RE: HORIZON AT LEE 5 SSD-9827, 45 HONEYSUCKLE DRIVE (LOT 5 DP 1238761)

We are pleased to submit this Section 4.55(1A) application on behalf of Horizon Newcastle Pty Ltd. This application seeks consent for minor design amendments and changes to conditions of consent that have been identified as necessary during the ongoing detailed design in the lead up to the construction certificate phase to the Mixed Use Development approved under SSD-9827.

Unit Type S
SCALE 1:100 @ A1

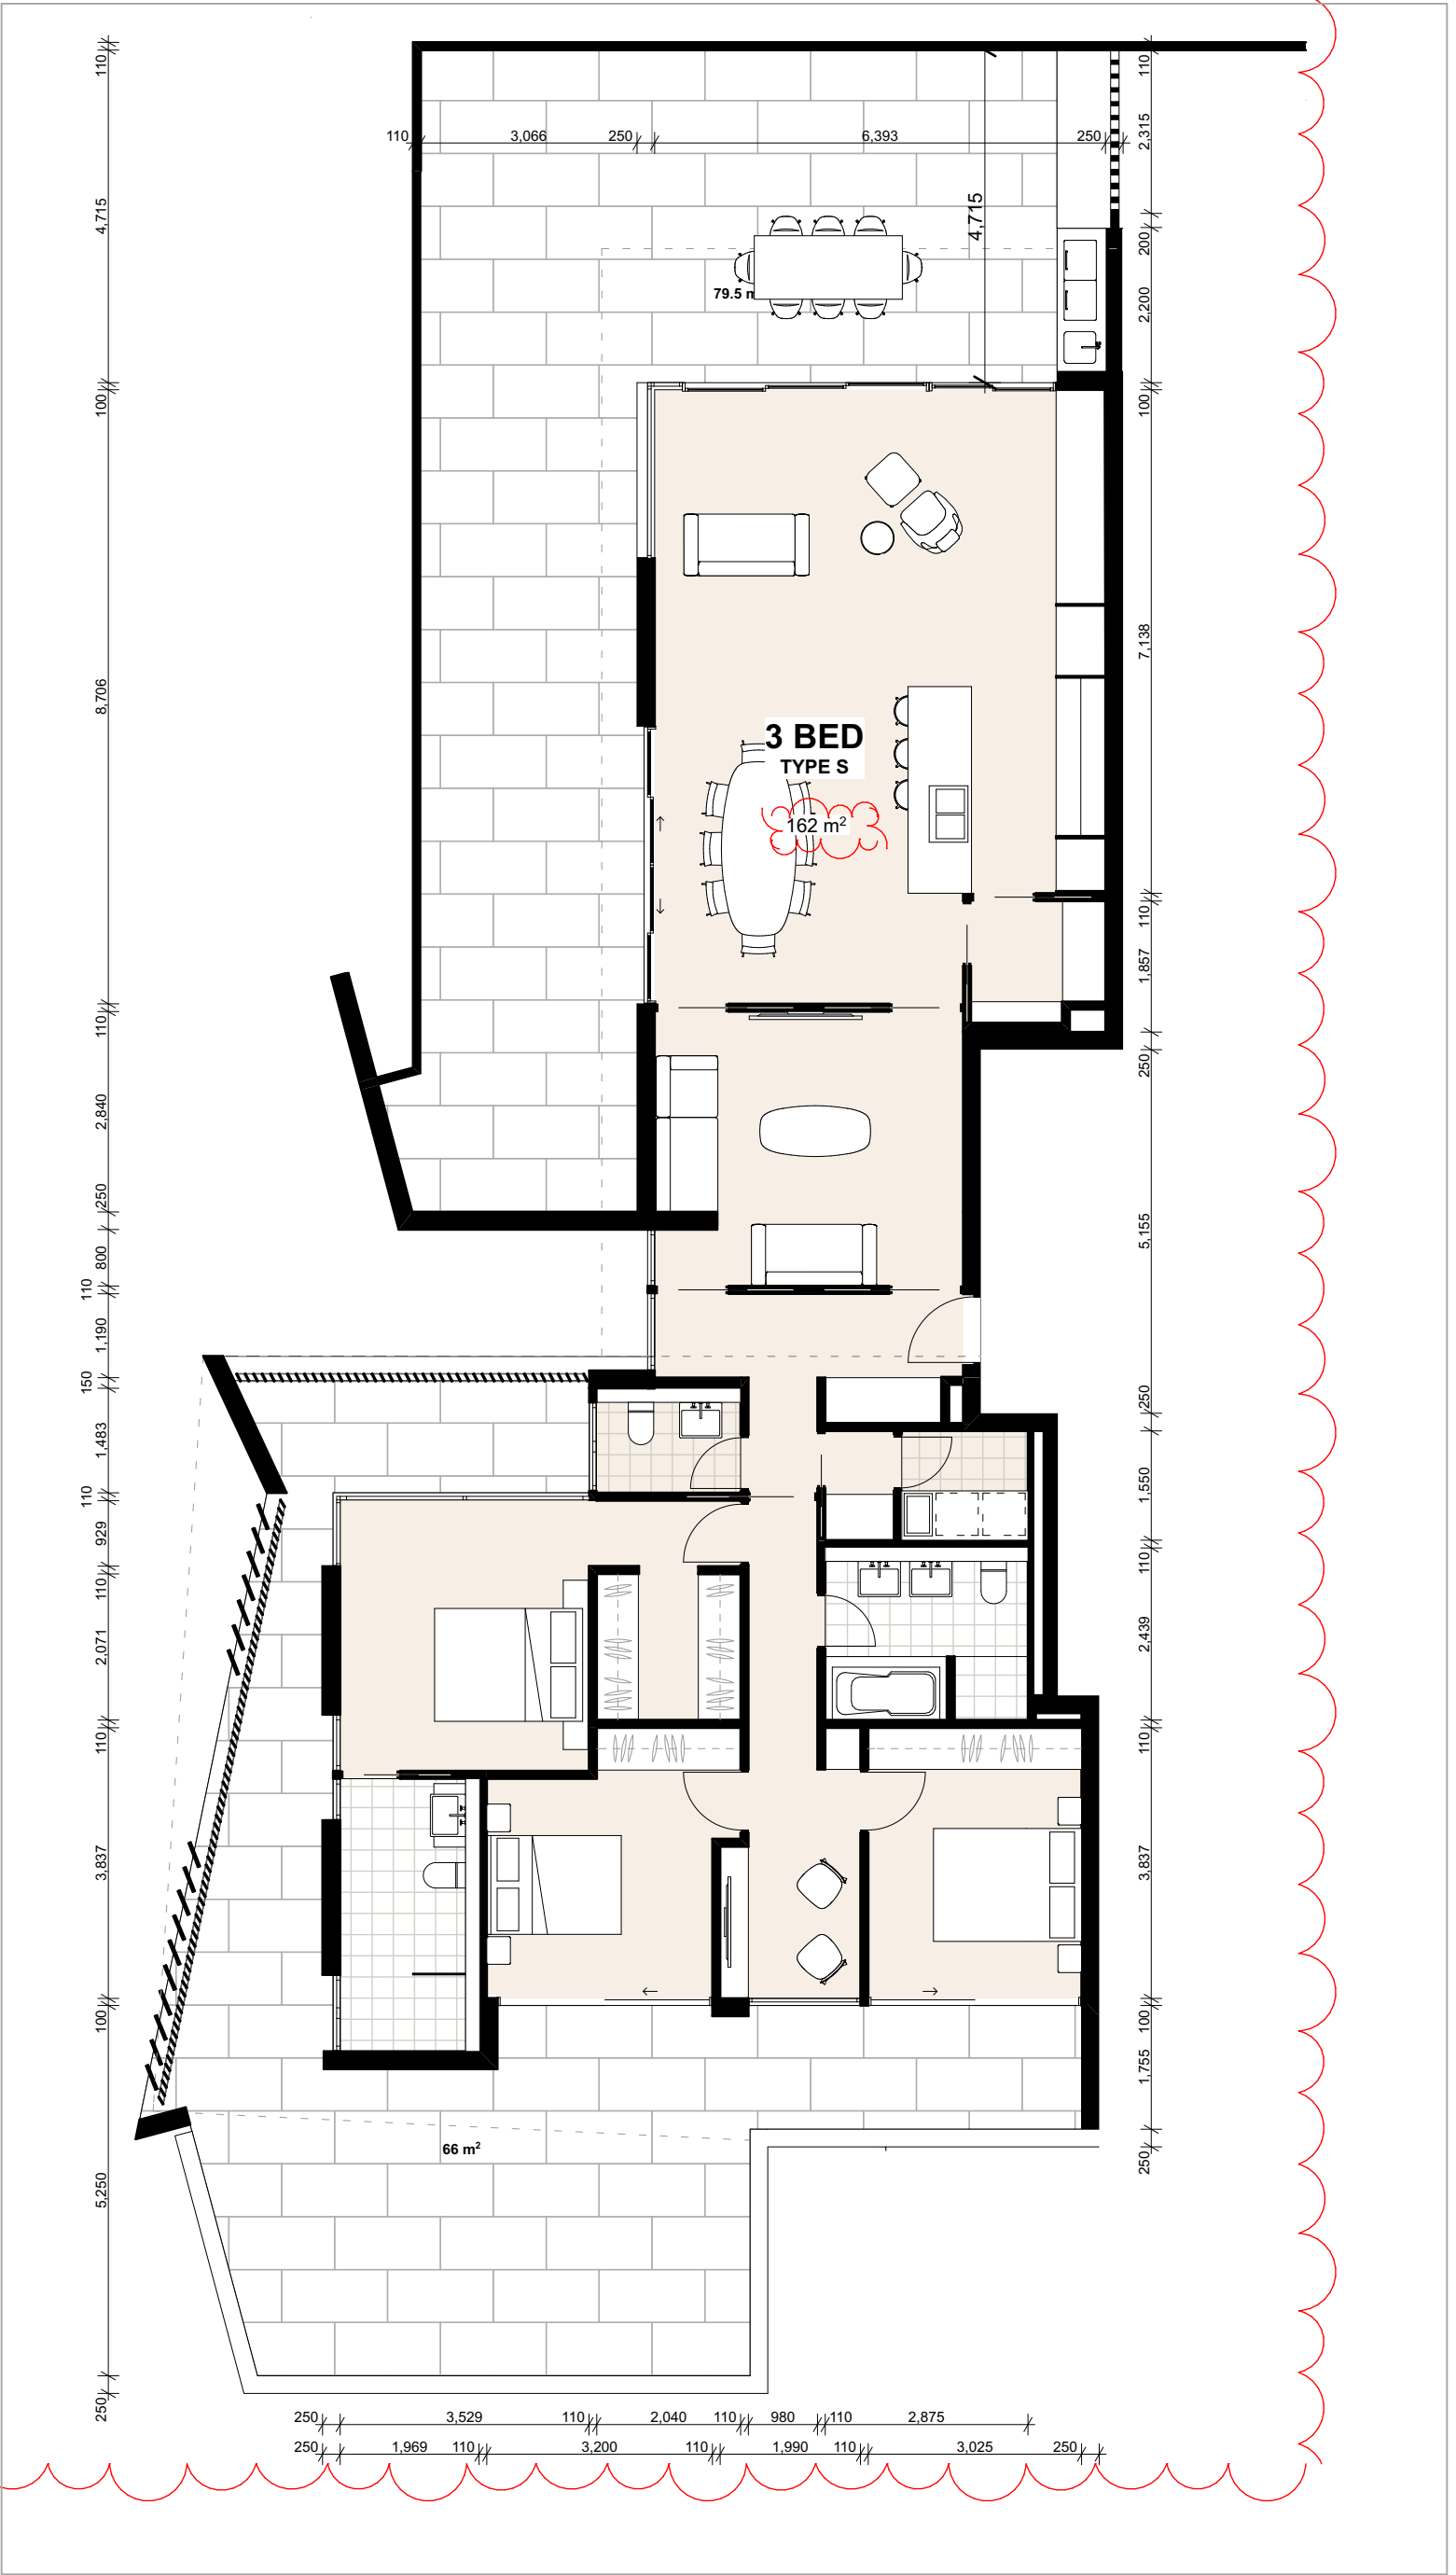
- As a result of the changes described above, these changes have been reflected in the Unit Types Q, R, S and T.

Unit Type U
SCALE 1:100 @ A1

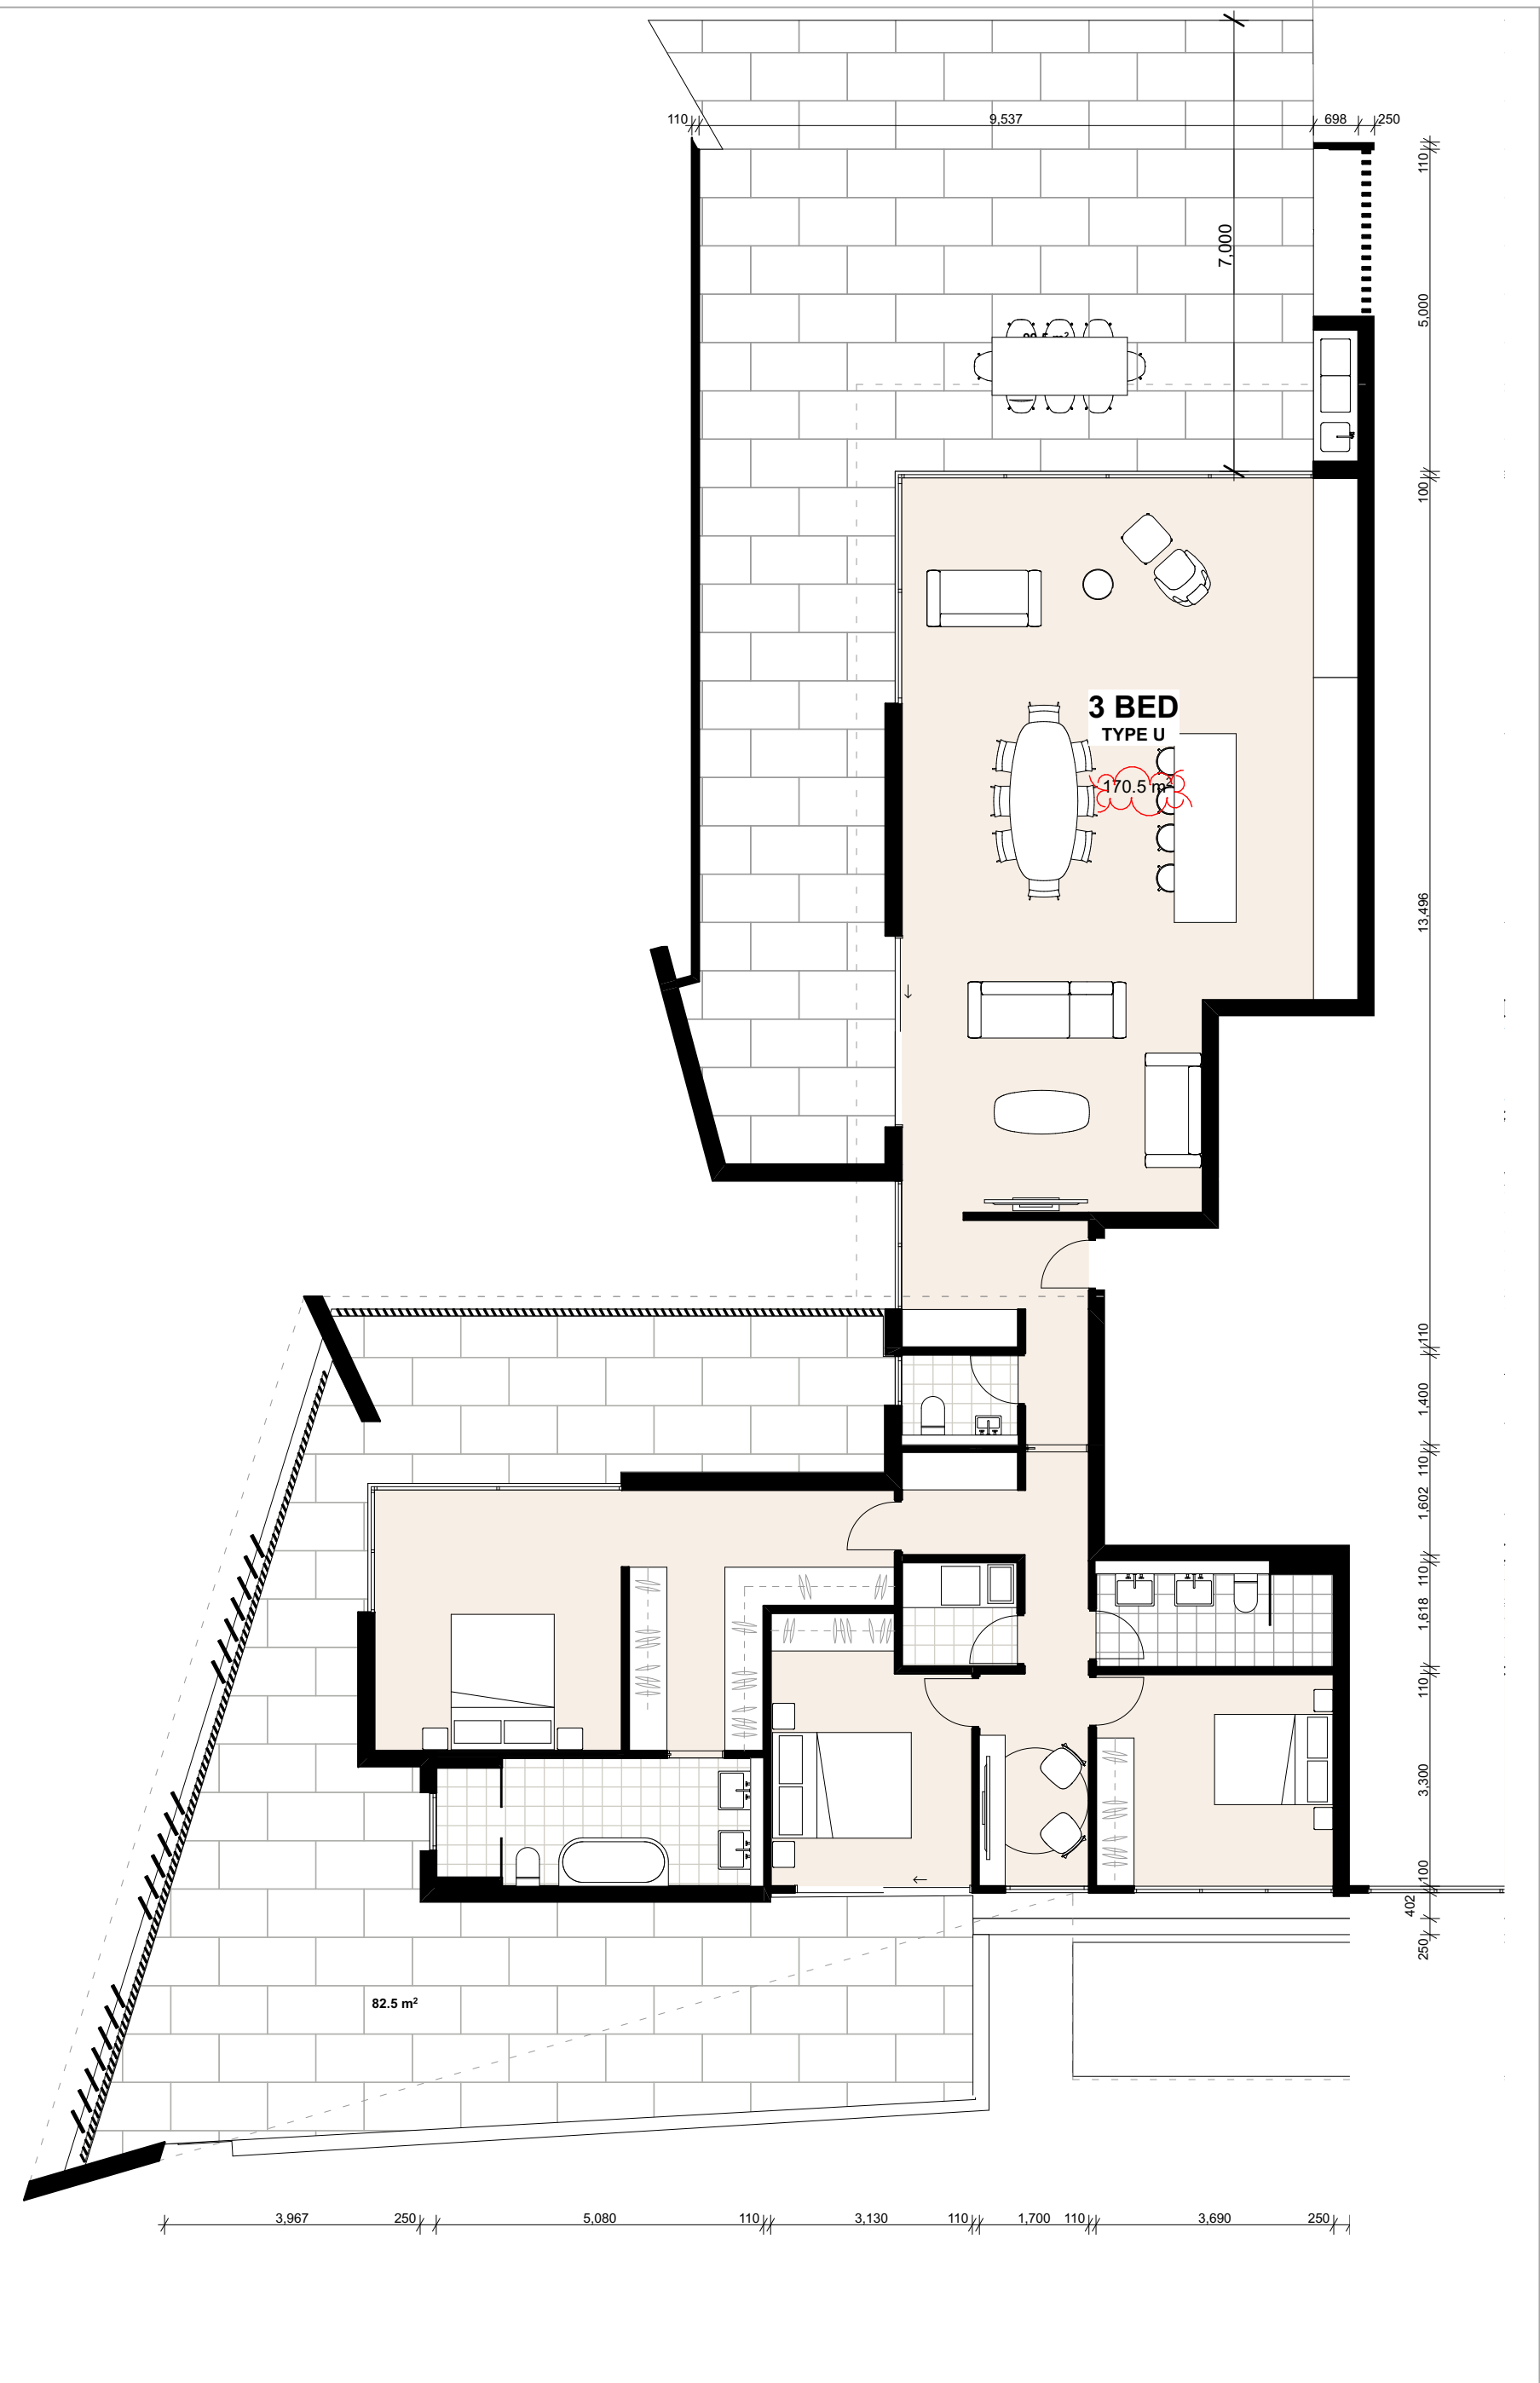
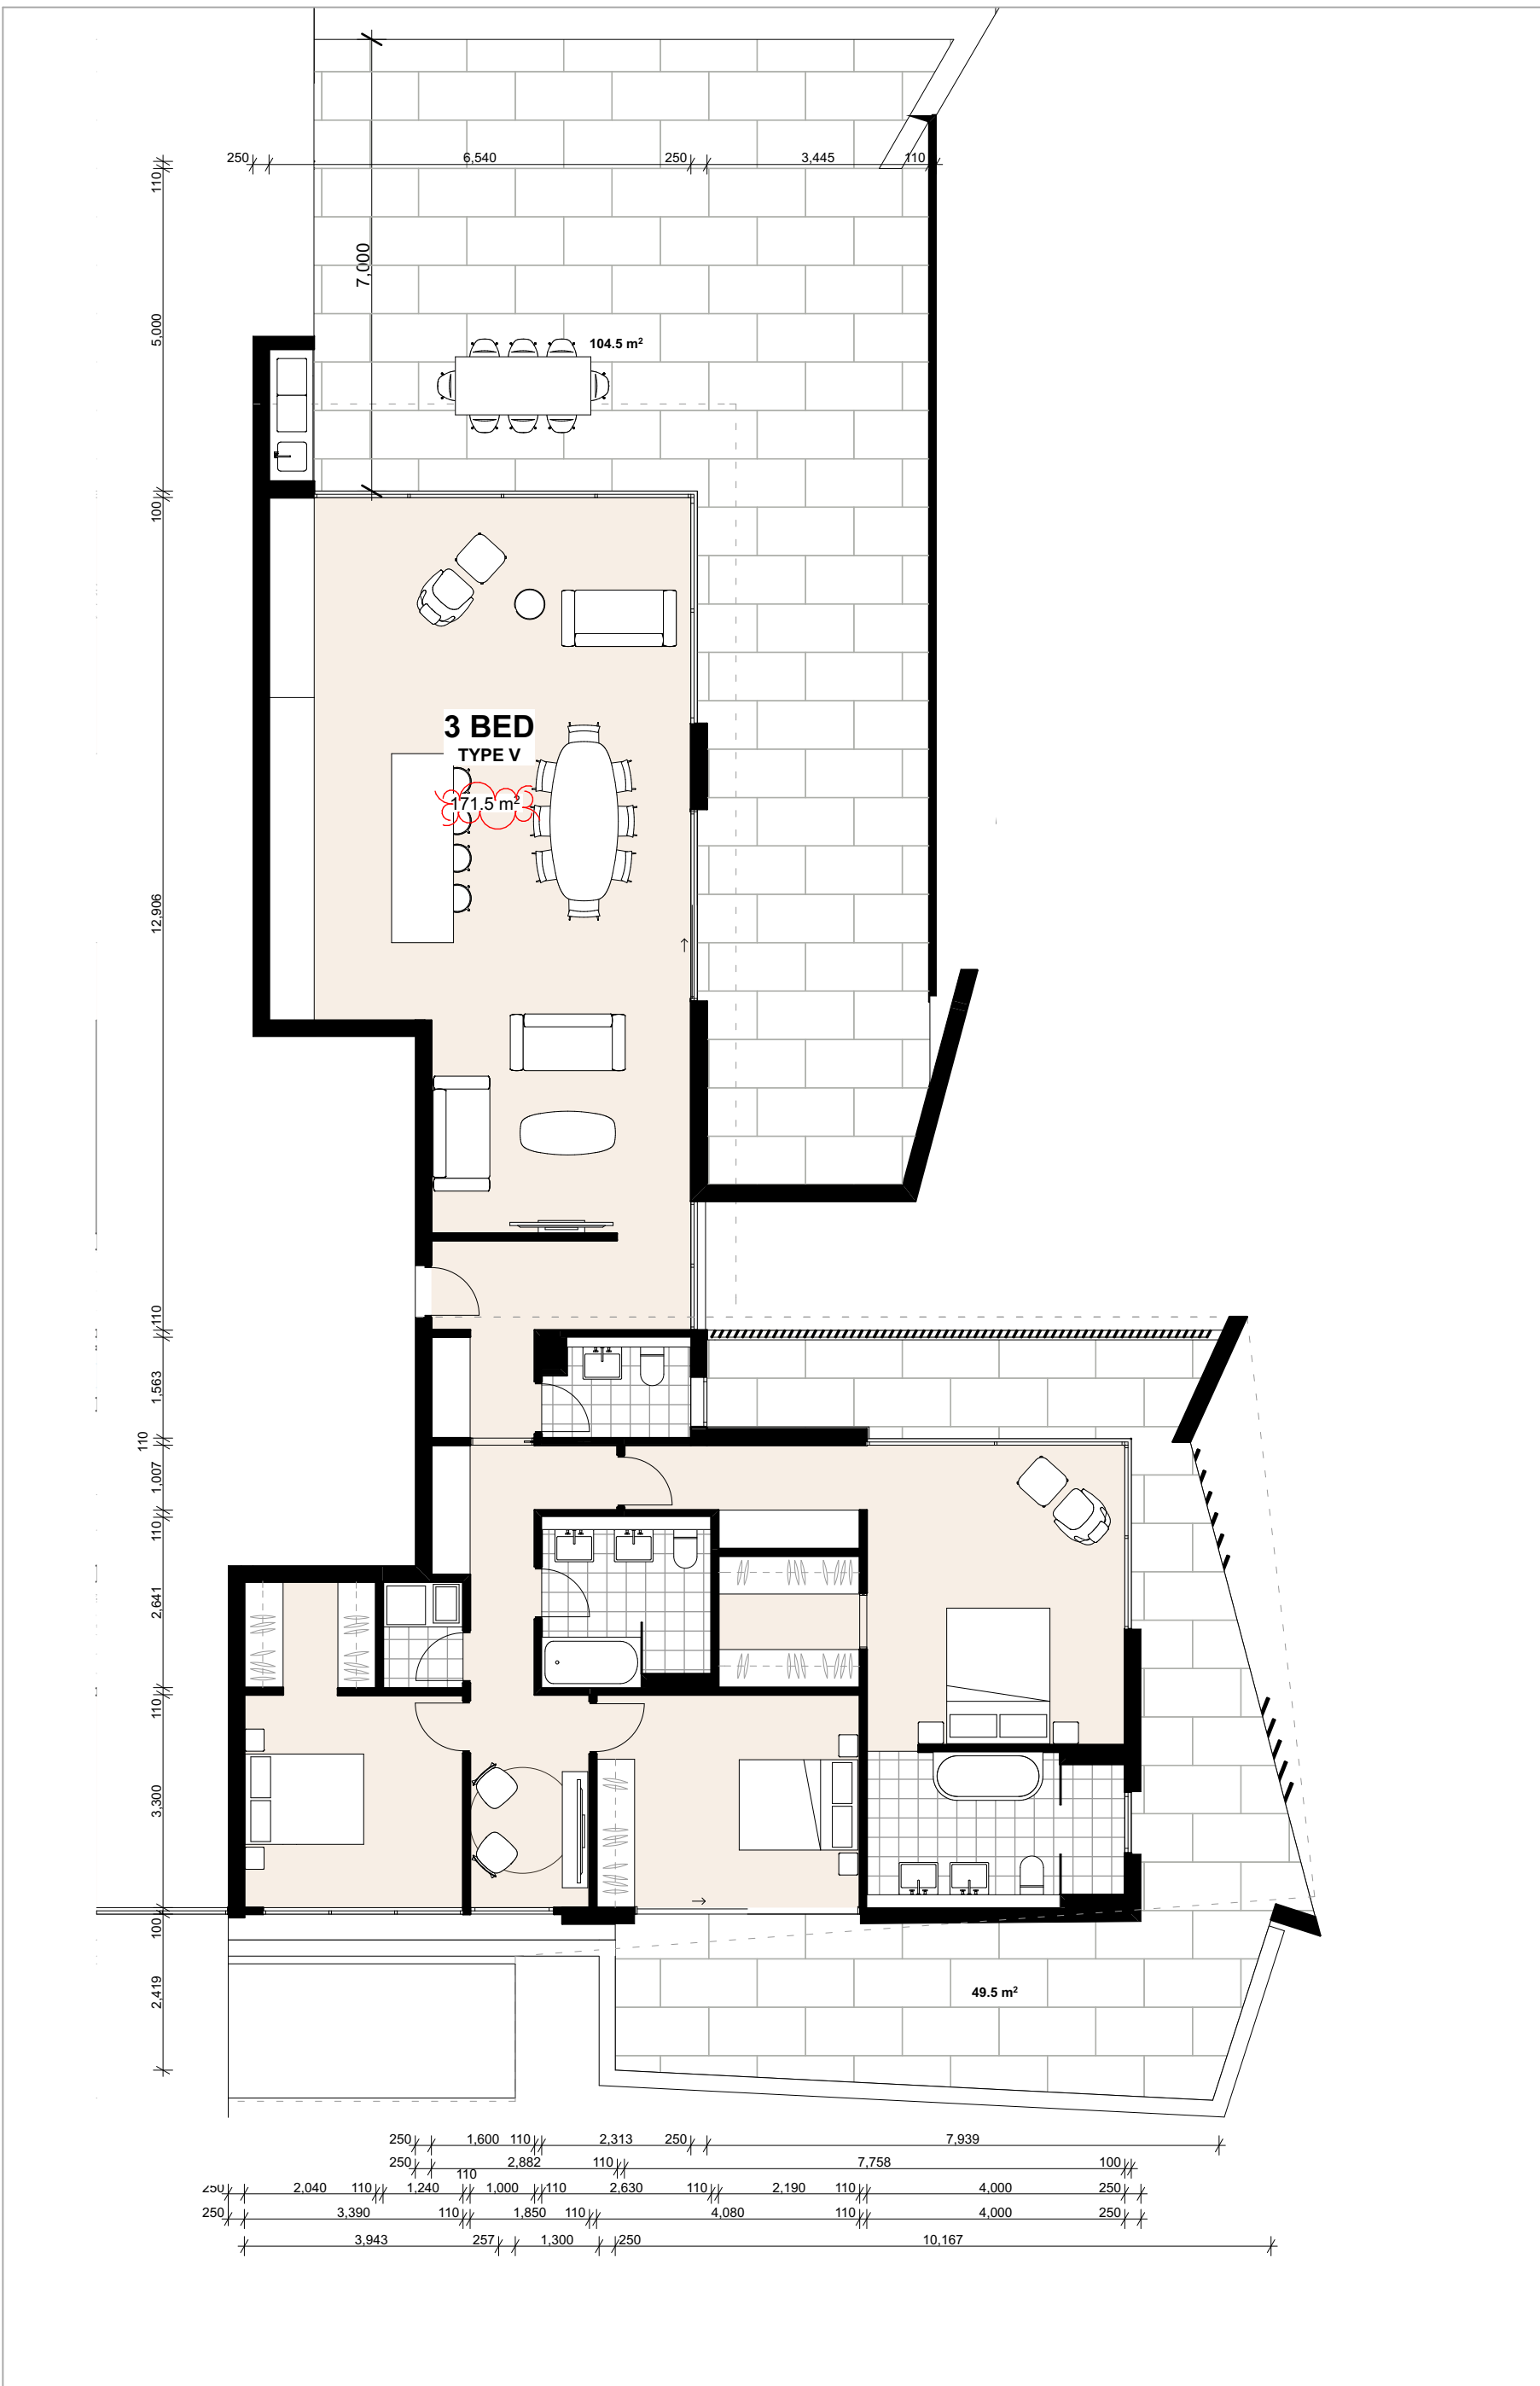
- Design rationalisation and minor changes to the Penthouse units on Levels 8 in the western building.
- The habitable areas of Units WP-1 and WP-2 have been slightly shifted further north by 2.3m. The balcony dimensions remain to exceed ADG requirements in terms of minimum depth and area. The minor amendment has result in an increase in area of:
 - W-P-1 increase of 10m²
 - W-P-2 increase of 15.5m²
- The unit facades to the eastern and western side of the units in the western building have been amended.
- The roof has been amended to reflect the changes to the building core and units below.
- As a result of the changes described above, these changes have been reflected in the Unit Types U and V.
